From: Nicola Moore on behalf of Planning.Responses
Sent: 13 November 2019 09:35
To: Planning Scanning
Subject: FW: Planning Consultation on: BR/282/19/PL

APPLICATION NO: BR/282/19/PL

Site Address: The Beach Hotel, former Mud Club & 2-4 Waterloo Square Bognor
Regis PO21 1SU

Description of Works: Redevelopment into 49 No apartments consisting of 24 No 1 & 25 No 2 bed apartments & 2 No commercial units (A3 Restaurant & Cafe). This application affects the character & appearance of The Steyne, Bognor Regis Conservation Area & may affect the setting of a listed building.

Document Title:
Rear Section - Elevation 4-4

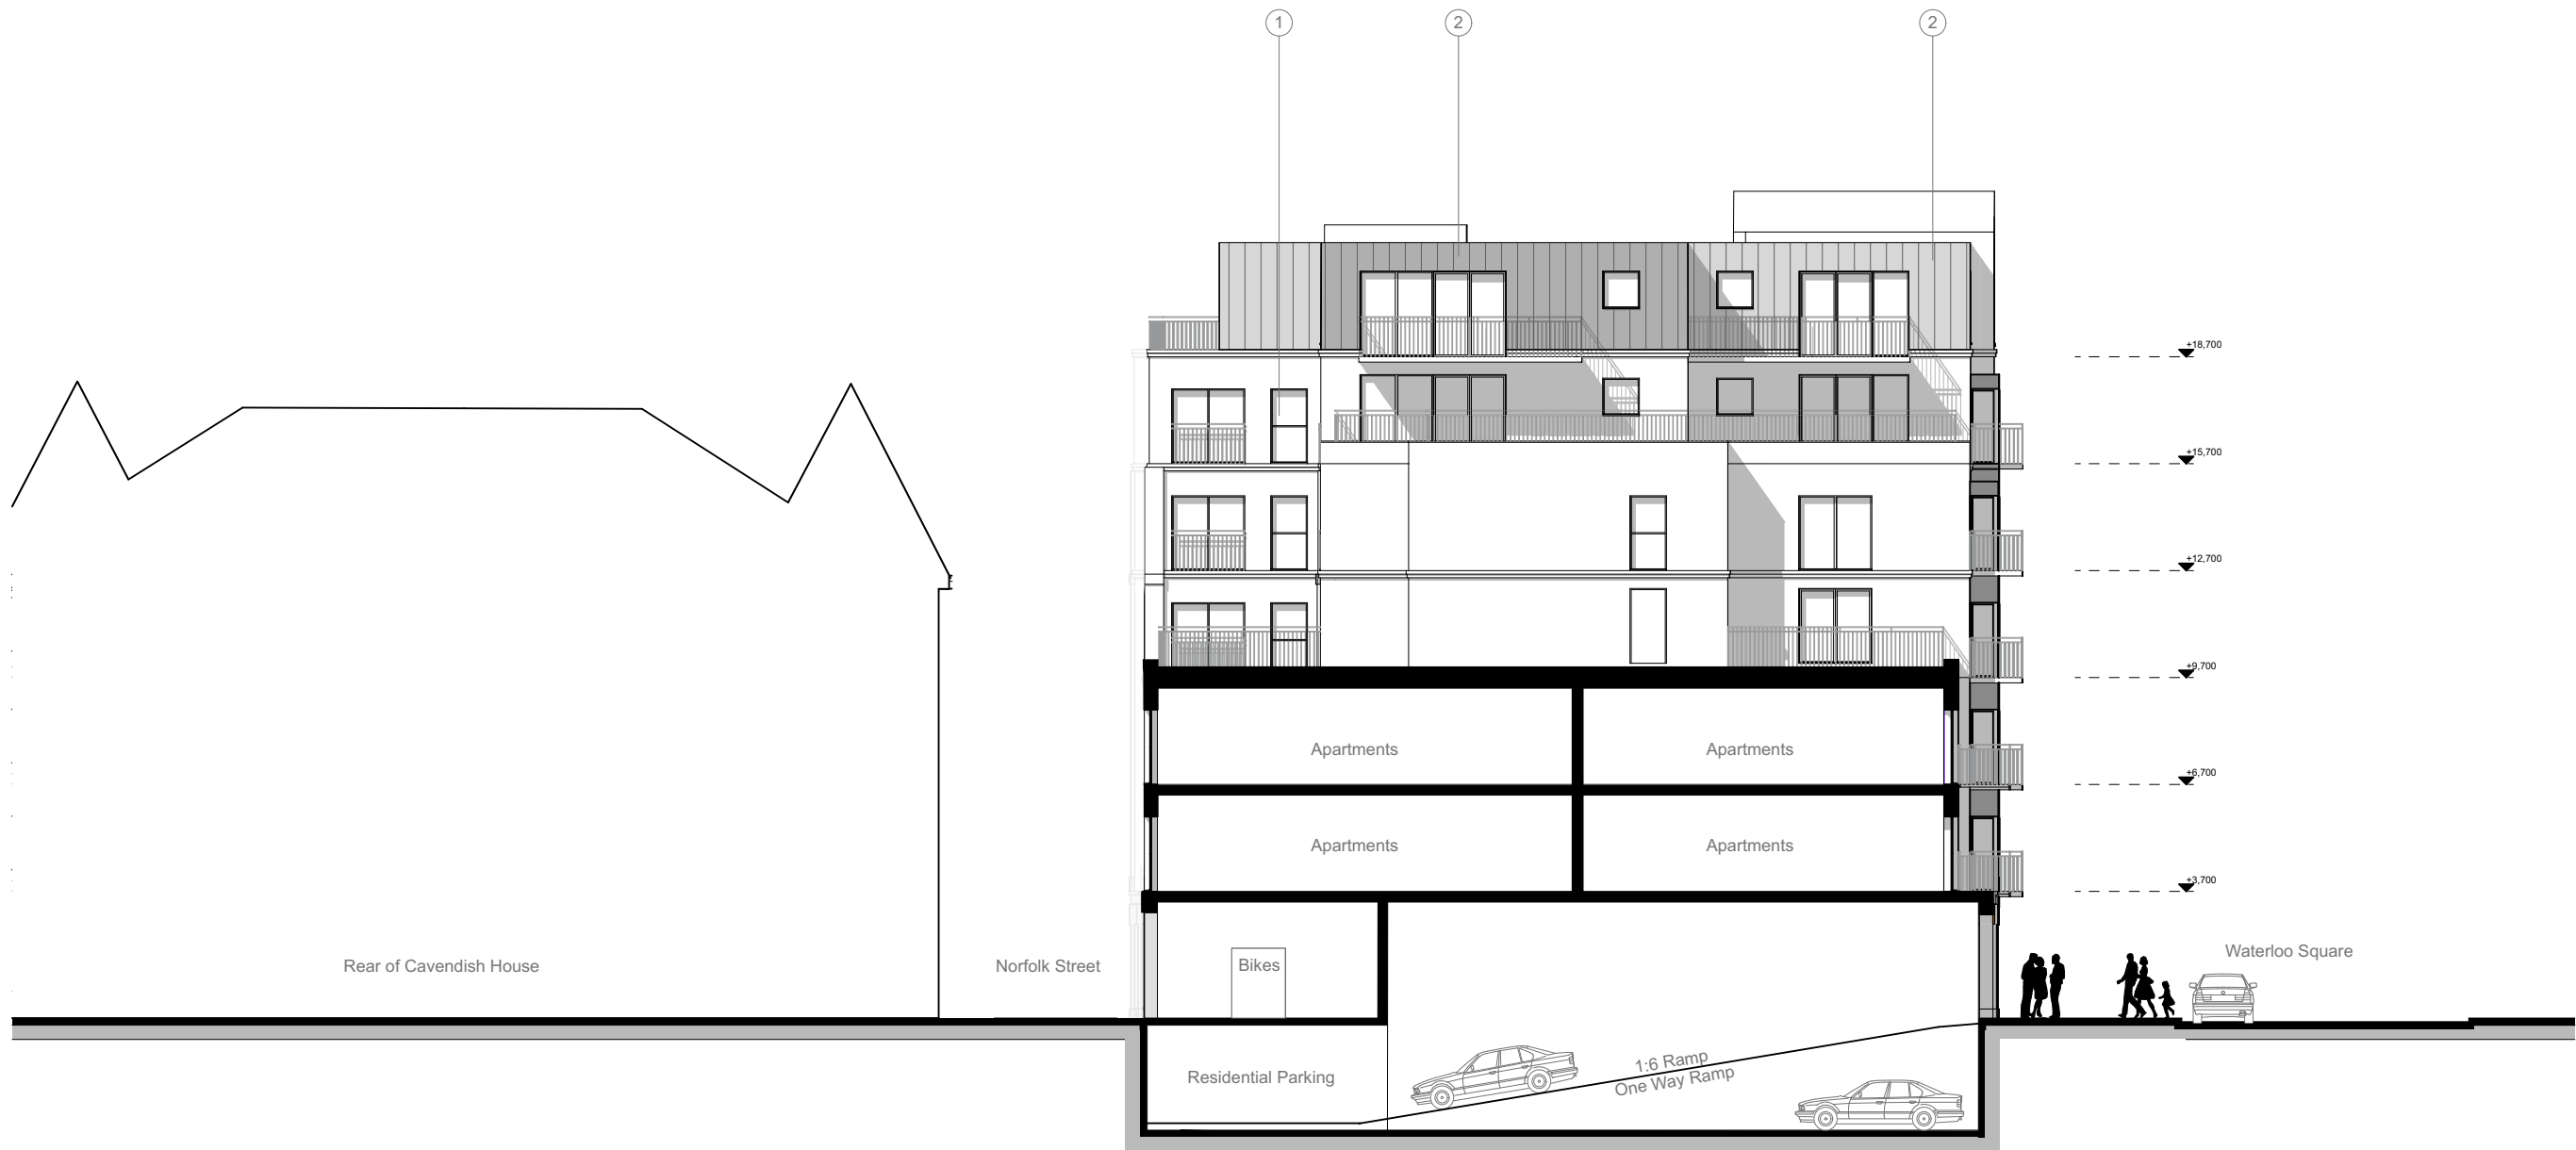
I feel this application is not suitable as it will be far to tall at 6 stories high and will not be within keeping of their surrounding area and the style of the buildings present the original building was 3 stories high and i feel this should be kept to also having the entrance to the underground car park off of Waterloo square where many ppl walk along and children run along in-front of their parents i can see accidents happening the parking spaces are far to few for 49 apartments especially as there is no off site parking available and the square is always full with cars using the pay and display meters also Norfolk street is very narrow and to get vehicles les in and out and up and down that road is very difficult and would cause accidents on the esplanade as there is blind spots at the esplanade and Norfolk junction as it is without a 6 story building that will add to the wind tunnel we already have in Waterloo square and Queensway
